Our Ref: ID 3264
Your Ref: SSD-67173718

State Significant Development Application for New Eileen O'Connor School

Thank you for the opportunity to provide comment on the State Significant Development Application (SSDA) for the proposed new Eileen O'Connor School at 84 Gavenlock Road, Mardi, the existing St Peters Catholic College site. It is understood that the proposal is for the construction and operation of a new school that will provide education and allied health facilities,¹ with **71 full-time equivalent (FTE) staff** and **200 students, children with special needs from kindergarten to Year 12**. It includes:²

PMF flood hazard behaviour

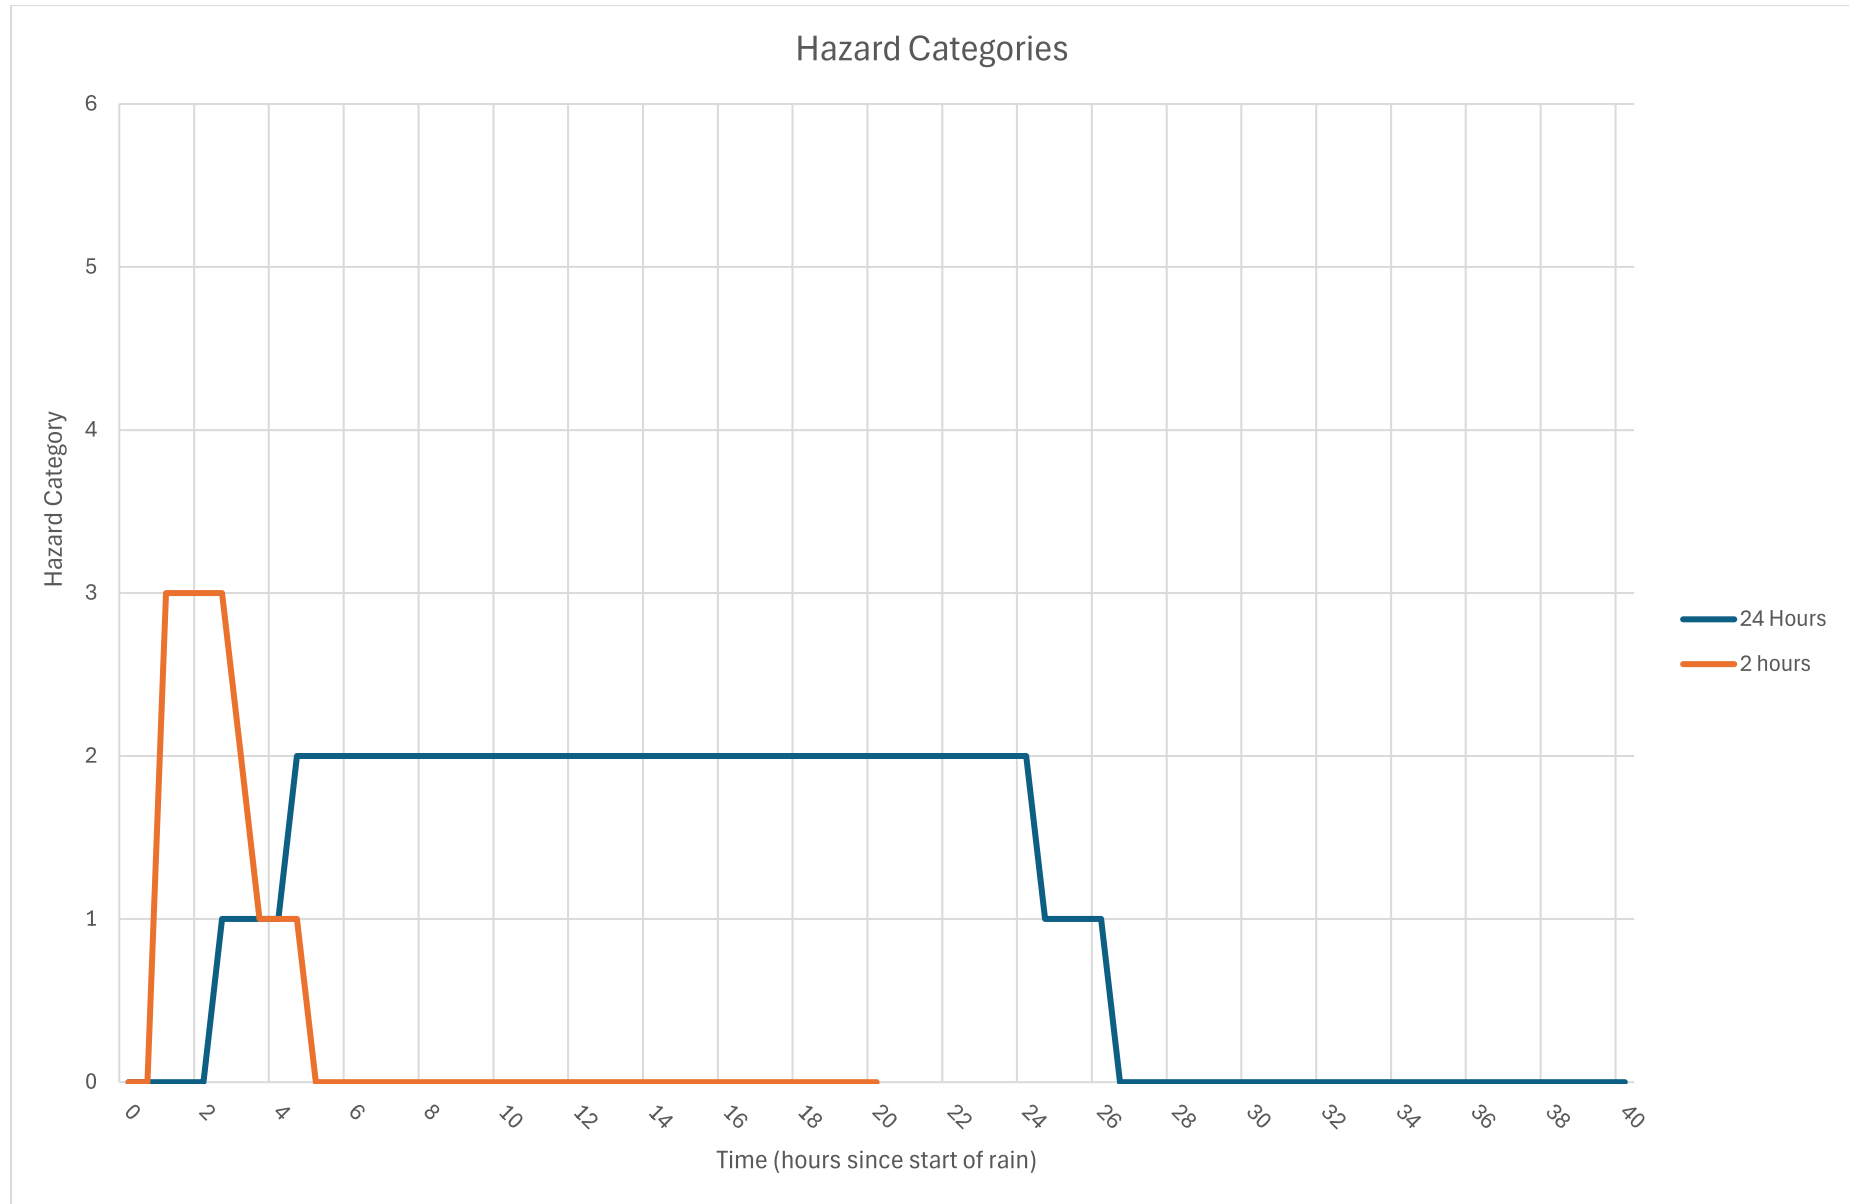
We note that the proposed route to Westfield Shopping Centre is impacted by H5 flood hazard level in a PMF event,²¹ however, noting that more frequent events were not modelled. In addition, the flood risk assessment notes that flash flooding is not the only risk present in this area, and longer duration flooding and isolation may impact the site. We emphasise that the ‘shelter in place’ strategy is not an endorsed flood management strategy by the NSW SES for *future development*. We recommend referring to the considerations in the [Shelter in Place Guideline](#) (DPHI, 2024) and considering the nature

We recommend that students are able to be collected by carers rather than relying on evacuation to Westfield Shopping Centre for 200 children with *a range of physical, intellectual and emotional needs*²⁸ for the entire duration of isolation. We emphasise that the location of appropriate evacuation centres in a flood event is determined by a risk-based assessment, in consultation with the Welfare Services Functional Area and other stakeholders. Furthermore, the proposed route to the proposed evacuation location, the Westfield Shopping Centre, is impacted by H5 flood hazard level in a PMF event.
